2 February 2012

Re: Cobbora Coal Project (MP 10_0001) – project update

Indicative Project Layout

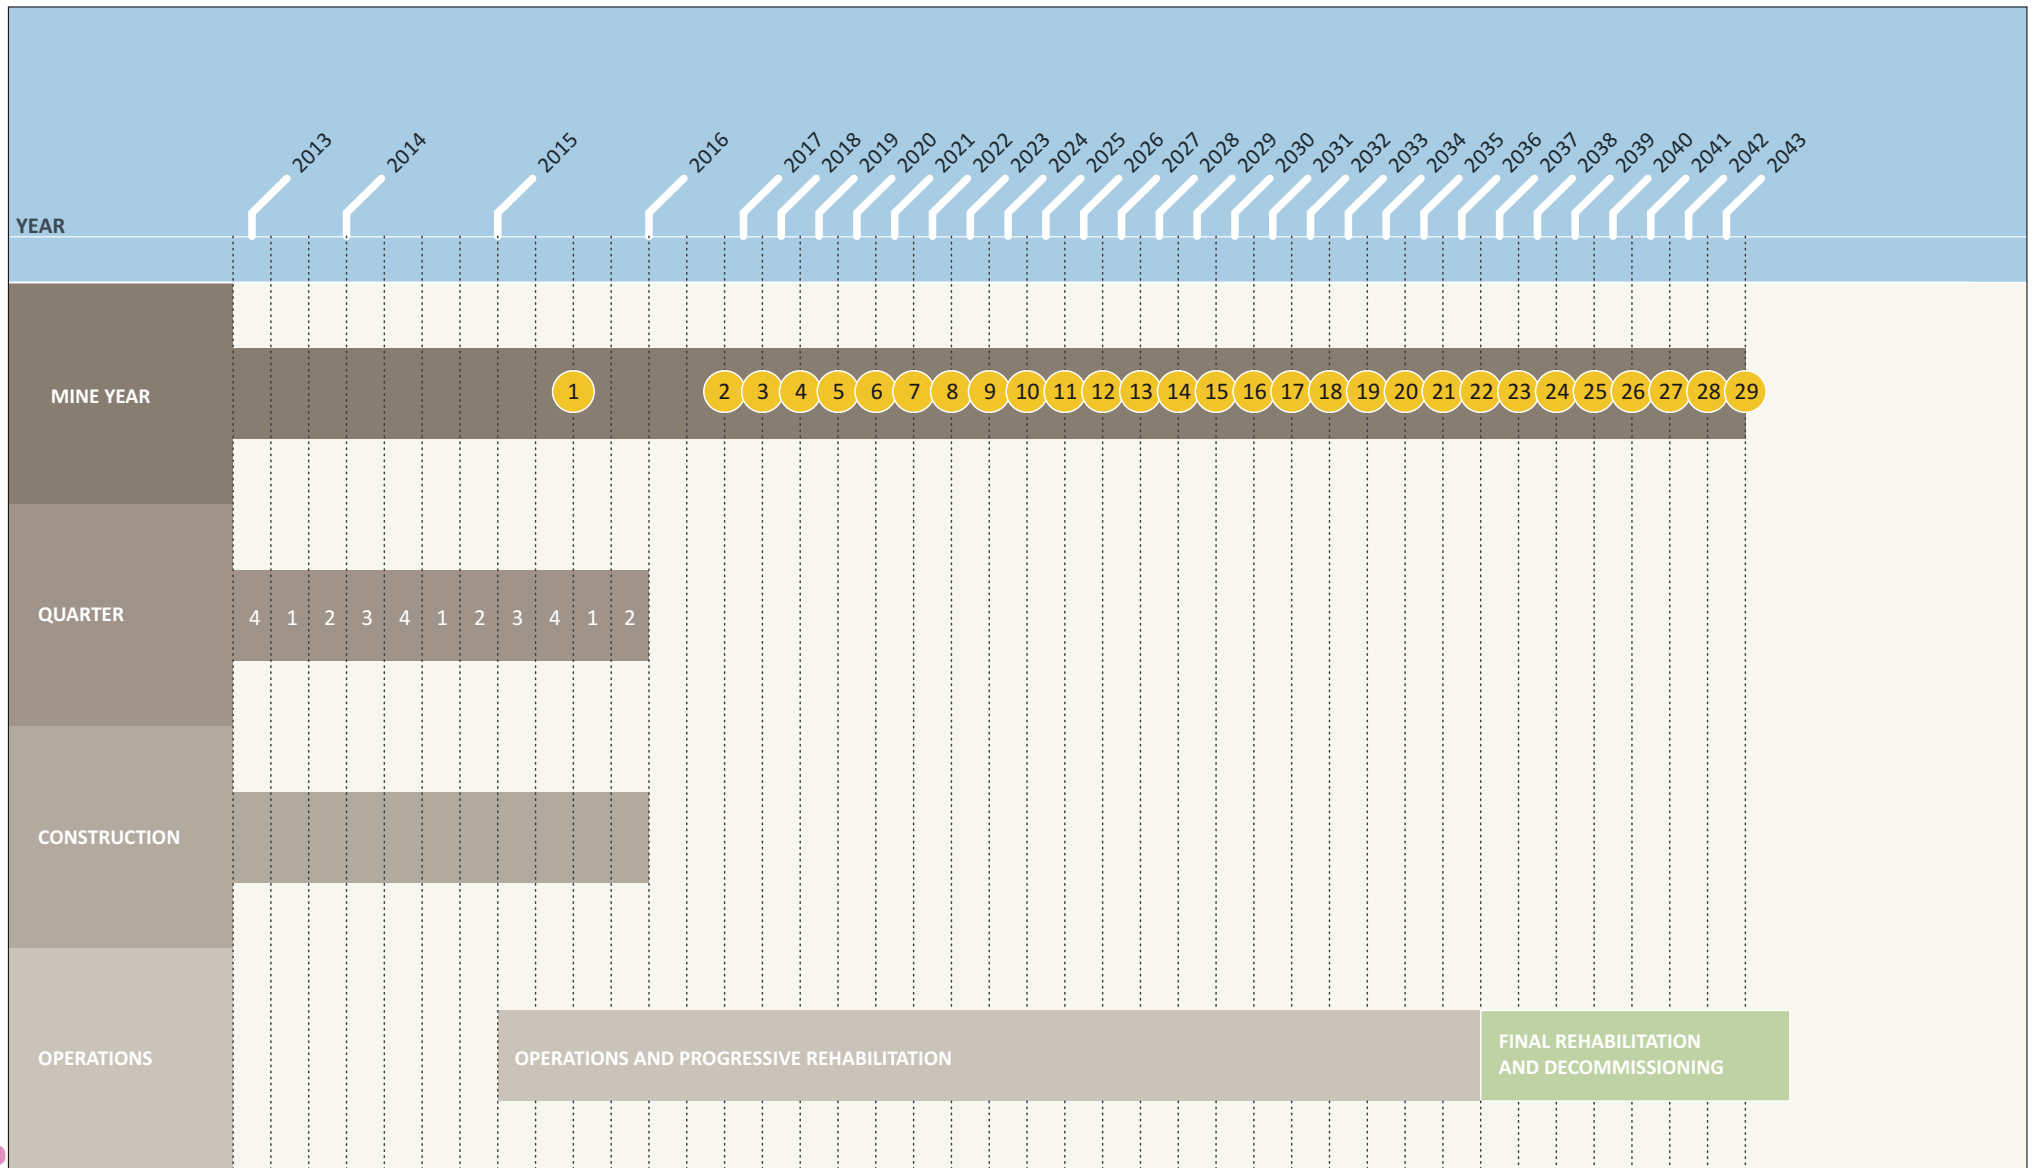
An updated project layout is provided in the attached figure.

It is no longer proposed to build this conveyor. Instead, the rail spur will extend from the Dunedoo-Gulgong rail line to the CHPP that will be adjacent to the mine area. The proposed rail spur will be approximately 28 km long, including the balloon loop. The rail spur will pass largely through cleared agricultural areas (Agricultural Suitability Class 3 and 4). It will be constructed on land owned by Cobbora Holding Company Pty Limited.

The CHPP and associated coal stockpiles have been moved approximately 1 km to the east to be adjacent to the rail loop. This is further from the banks of Laheys Creek.

It is proposed to construct a Spring Ridge Road diversion that will join Spring Ridge Road to Sweeneys Lane and to realign the northern section of Sweeneys Lane to improve access to the Golden Highway. A road realignment will also be required south of Suzanne Road to accommodate the rail spur.

Figure 3.14

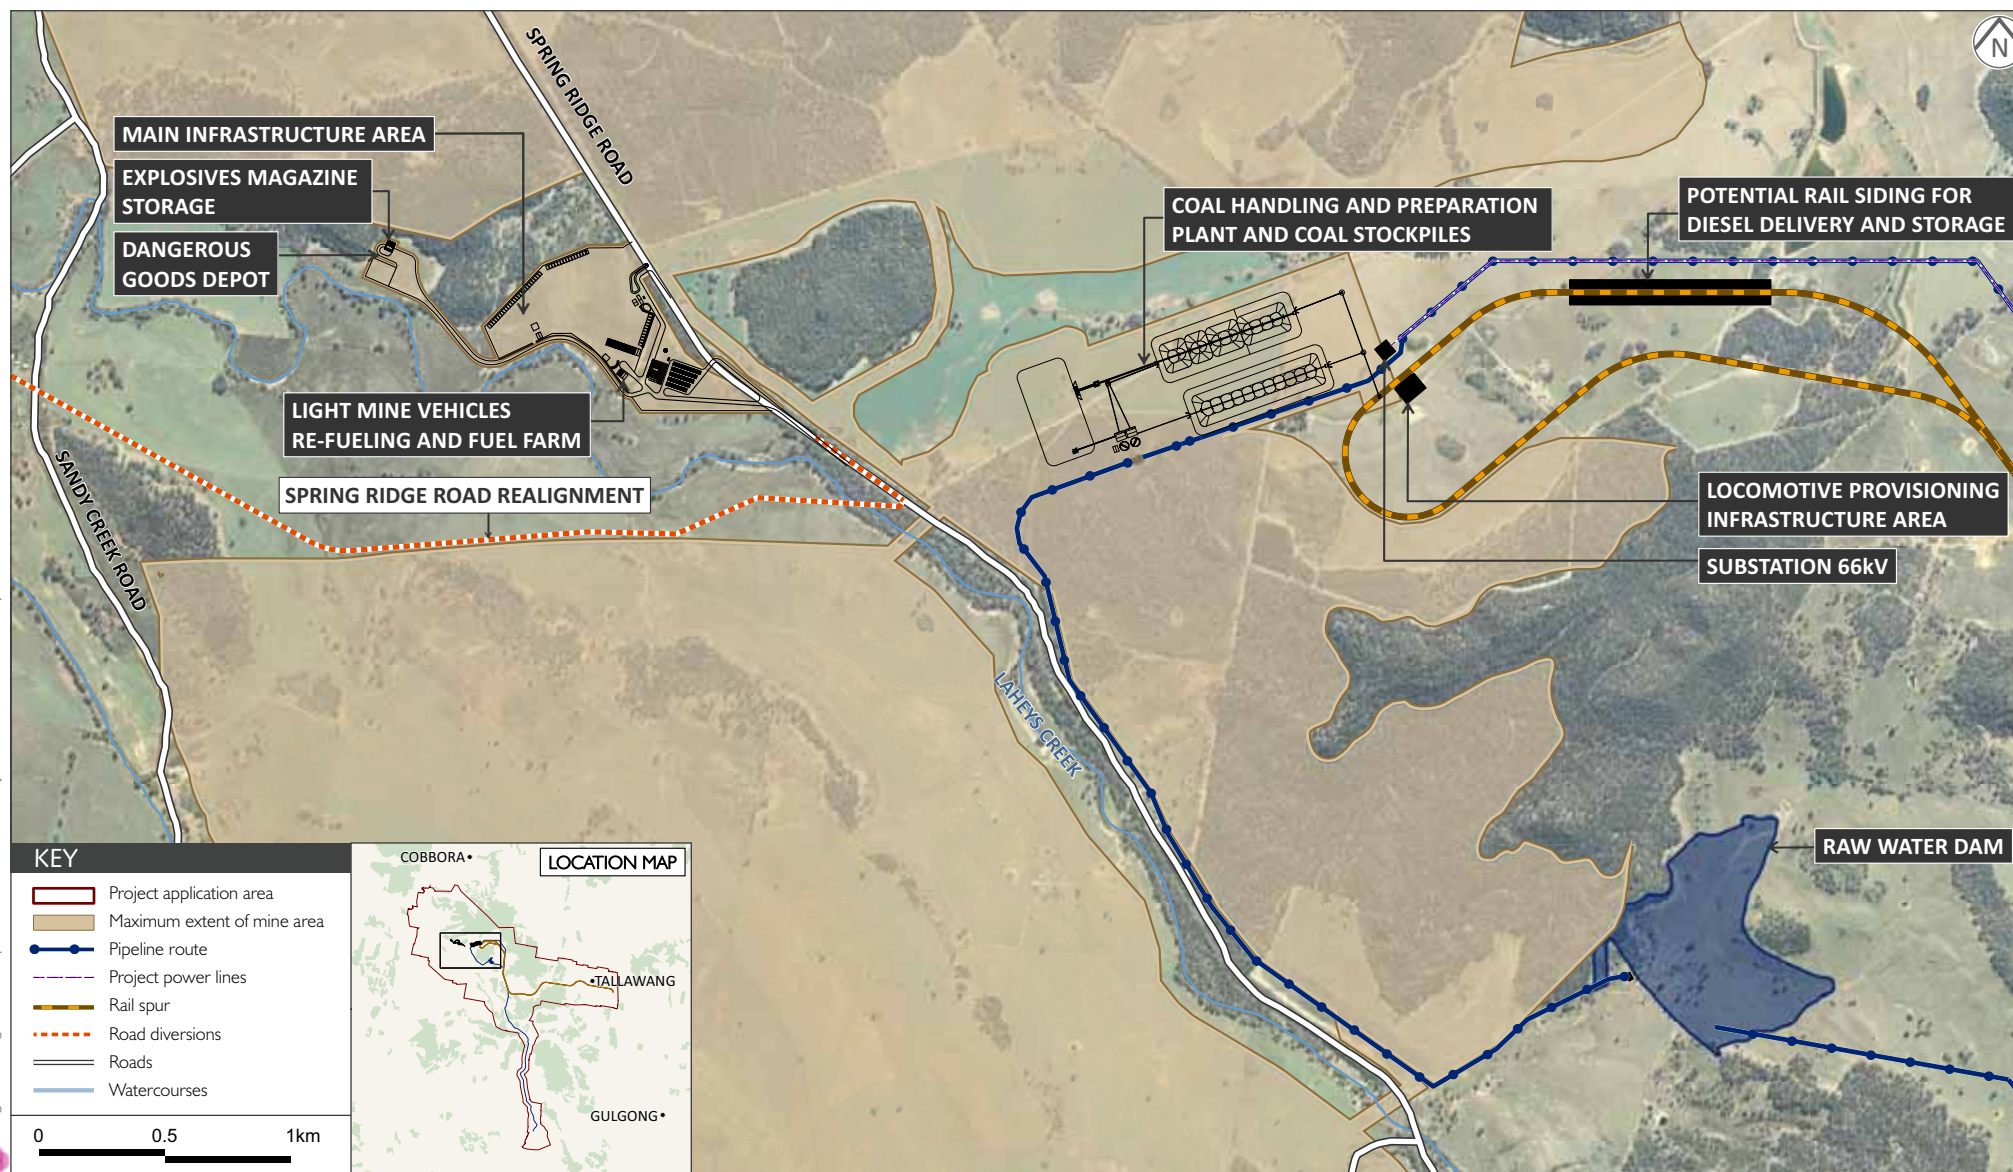
Development of the mine will require the closure of a northern section of Spring Ridge Road, a section of Sandy Creek Road and Danabar Road early in the mine development. Dapper Road will need to be closed in approximately Year 12 of operations.
